Warragamba Dam Raising Project SSI-8441

Submission by Ted Woodley¹

11 December 2022

Figure 3-2. Relative contribution different river catchments in range of Hawkesbury-Nepean Valley floods

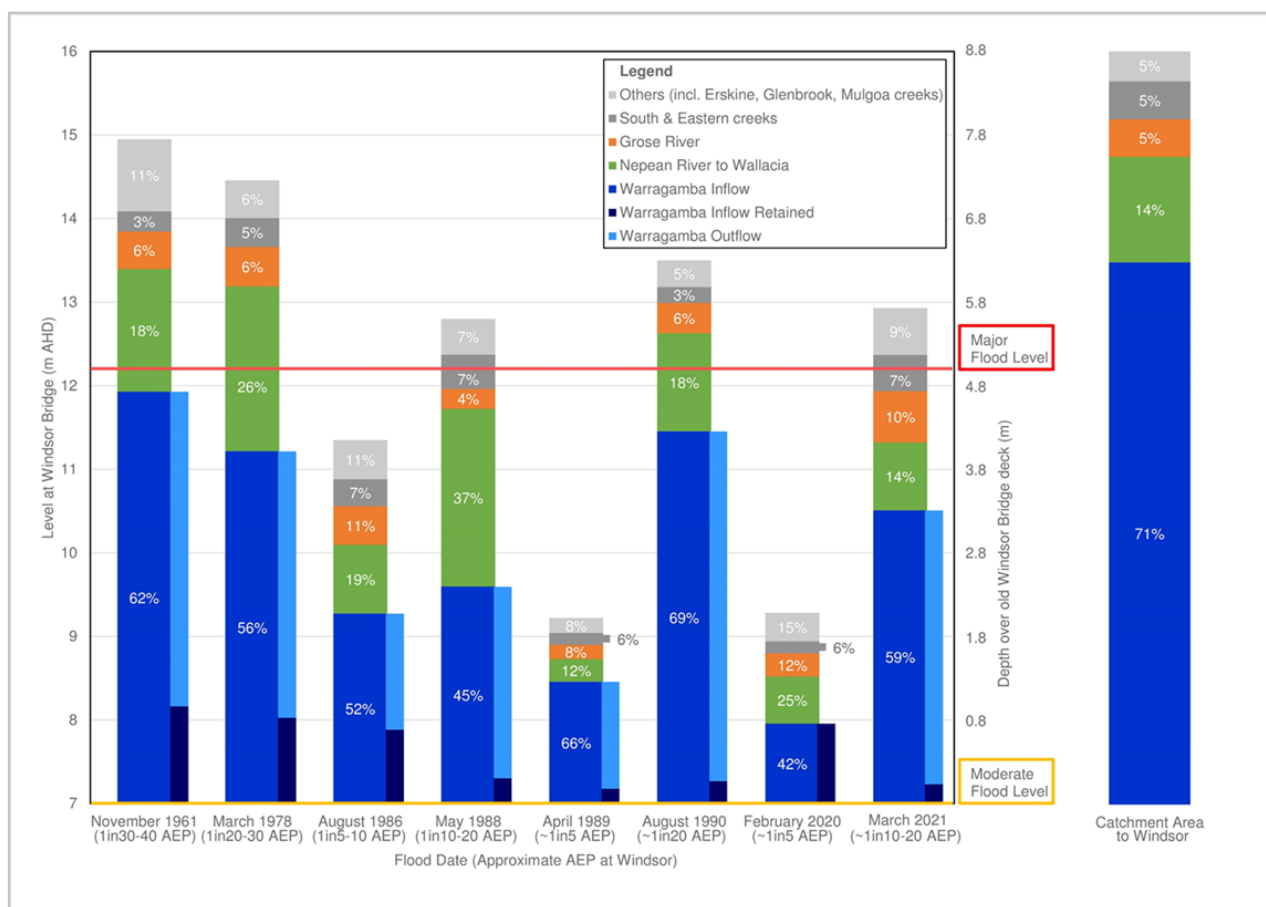
“The large Warragamba Dam catchment historically contributes up to 70 percent of flows during flooding in the Hawkesbury-Nepean (see Figure 2).”

This statement is repeated throughout the EIS, but it is highly misleading and beside the point.

Figure 2 shows relative contributions from the Warragamba catchment for the eight largest floods in the sixty years since the Dam was commissioned. The Figure focuses on Warragamba inflows from its catchment (dark blue bars).

But inflows are irrelevant as far as downstream flooding is concerned, as is the ‘up to 70%’ contribution quote.

The only relevant contribution to flooding is the outflow from the Dam to the Valley (light blue bars), which is obviously less than the inflow by the amount retained in the Dam (black bars) – i.e. the spare capacity in the Dam at the time.

Figure 2 indicates that outflows from Warragamba Dam during the eight floods contributed 0% to

65% to downstream flooding, averaging slightly less than half:

- Warragamba Dam did not contribute at all to the February 2020 flood, as the Dam did not spill – it was at less than 50% capacity at the time.
- The maximum contribution to flooding from Warragamba Dam occurred in the August 1990 flood, at around 65%.

Another example of overstating the Warragamba Dam contribution is the comment (page 17) that for *“the recent large flood of March 2021 ... the large Warragamba Catchment contributed around 60 percent of flows for this event, with the other small catchments contributing around 40 percent combined.”* However, Figure 2 shows that whilst the Warragamba inflow for that flood constituted 59%, the outflow was slightly less due to retained inflows.
